REVISION/DEFERRED SUBMITTAL FORM

Site Address 8435 SE 47th Pl.

Permit Number 2202-225

Revisions to foundations

11

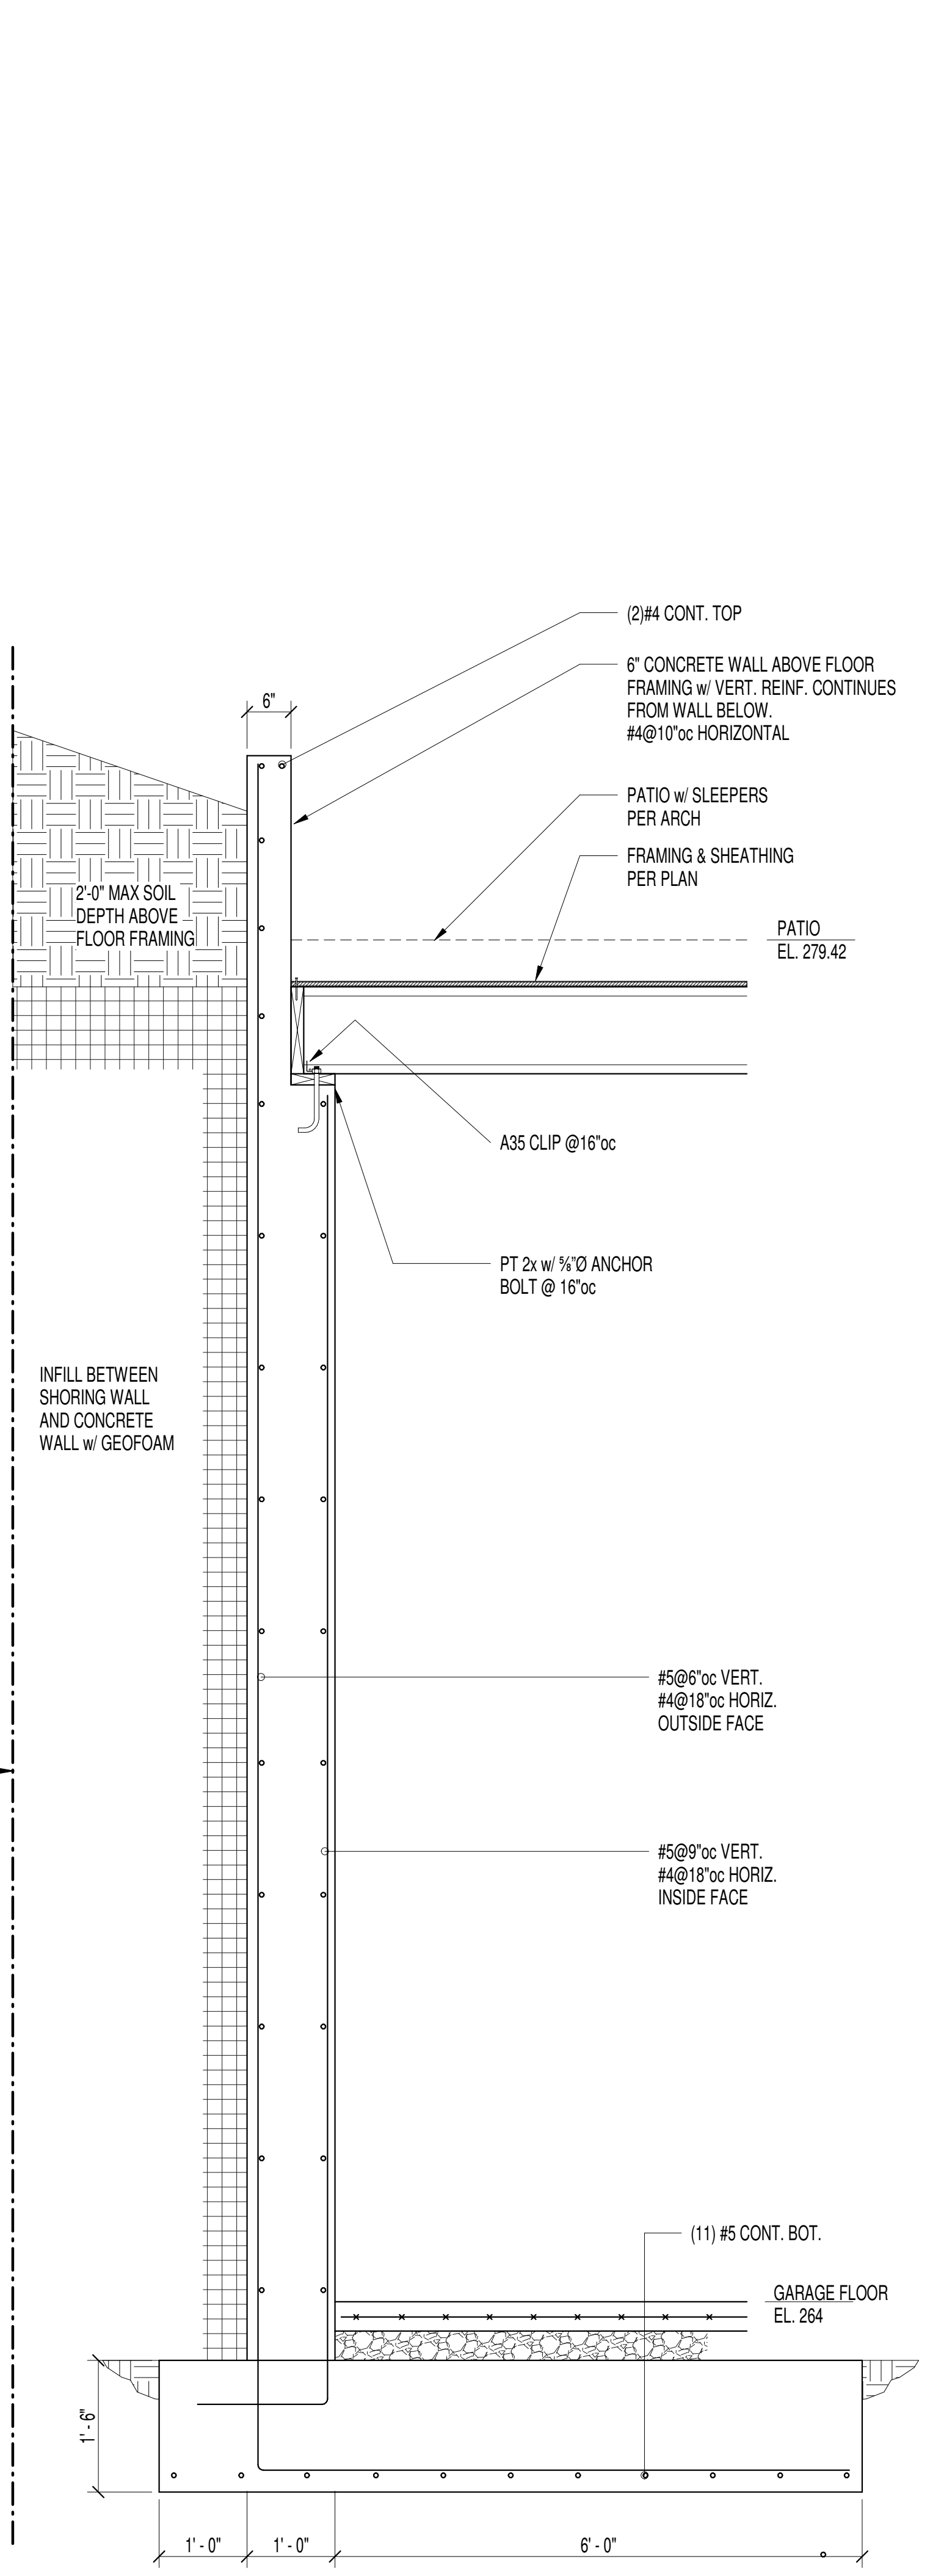
Sheet #	<u>S2.0</u>	Revised footing 11/S3.1
Sheet #	<u>S2.0</u>	Revised interior footing locations to be per revised arch
Sheet #	<u>S2.0</u>	Revised plan note #2 referencing hold-down detail
Sheet #	<u>S2.1</u>	Pin-piles removed at footings per soils engineer
Sheet #	<u>S3.0</u>	Added hold-down detail
Sheet #	<u>S3.1</u>	Revised footing 11/S3.1
Sheet #	<u>S3.2</u>	Revised details 9,10,11 to remove pin piles per soils engineer
Sheet #	<u>S3.2</u>	Revised to show platform framing 5/S3.2
Sheet #		
Sheet #		
Sheet #		
Sheet #		
Sheet #
